Braintree District Council/Chelmsford City Council/Essex County Council

**Written Summary of Comments made During ISH2 (Environmental) -
29/09/2022**

Longfield Solar Farm [PINS Ref: EN010118]

**1. Written Summary of Comments made by Gill Wynee-Williams ('GW')
(Landscape Architect from Wynee-Williams Associates acting for
BDC/CCC/ECC on landscape and visual matters)**

Outline Landscape Masterplan
Sheet A

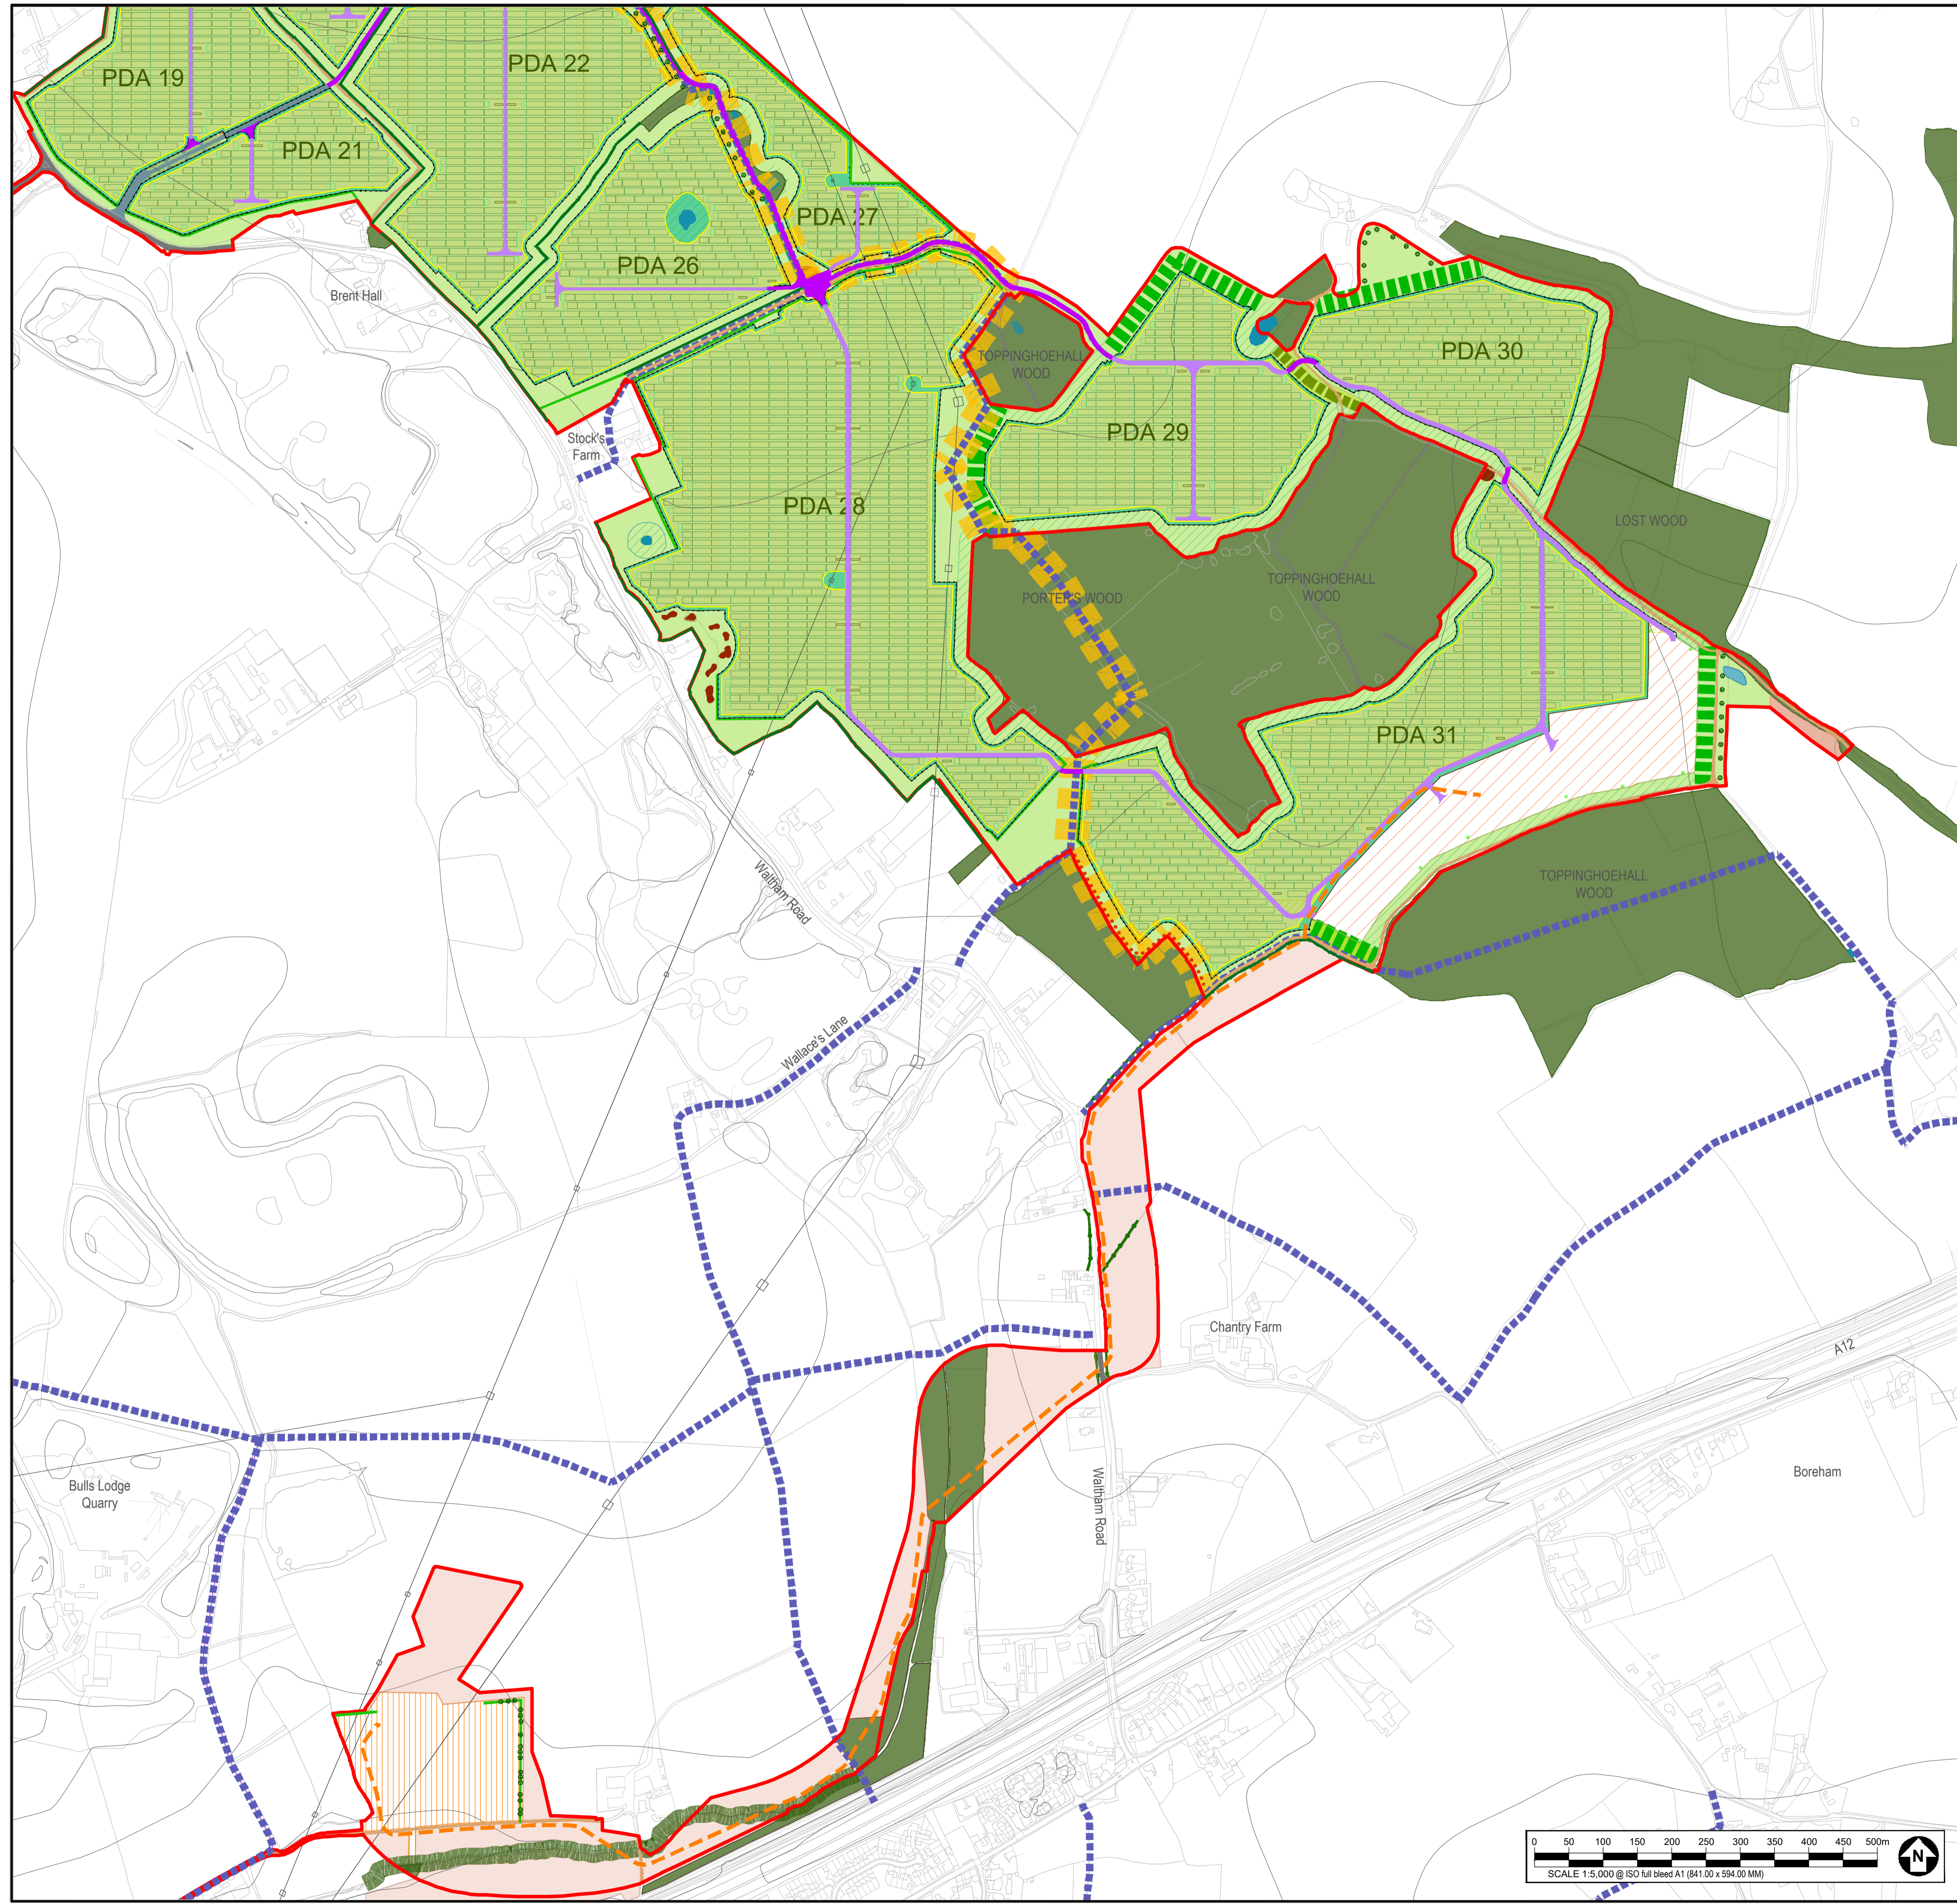
- 1.1 GW made comments in relation to PDA1 and mitigation. The effects of installing solar arrays in PDA1 are difficult to mitigate. PDA1 is located on the rising southern slopes of the Ter Valley, one of the most sensitive areas within the DCO limits. The solar arrays would be on rising ground above the valley floor and visible from the Essex Way as it climbs the slope to the side of Sandy Wood. It is appreciated that the landscape masterplan has sought to provide screening of the arrays from this view, but, because of the lie of the land it will take a long time for any mitigation planting to provide screening and the presence of the pylons and overhead cables mean that continuous mitigation planting is not possible along the field boundary.

- 1.2 If PDA1 is included in the development then advance planting of the field boundaries and proposed scrub area would assist in lessening the impact of the development in a shorter timescale.
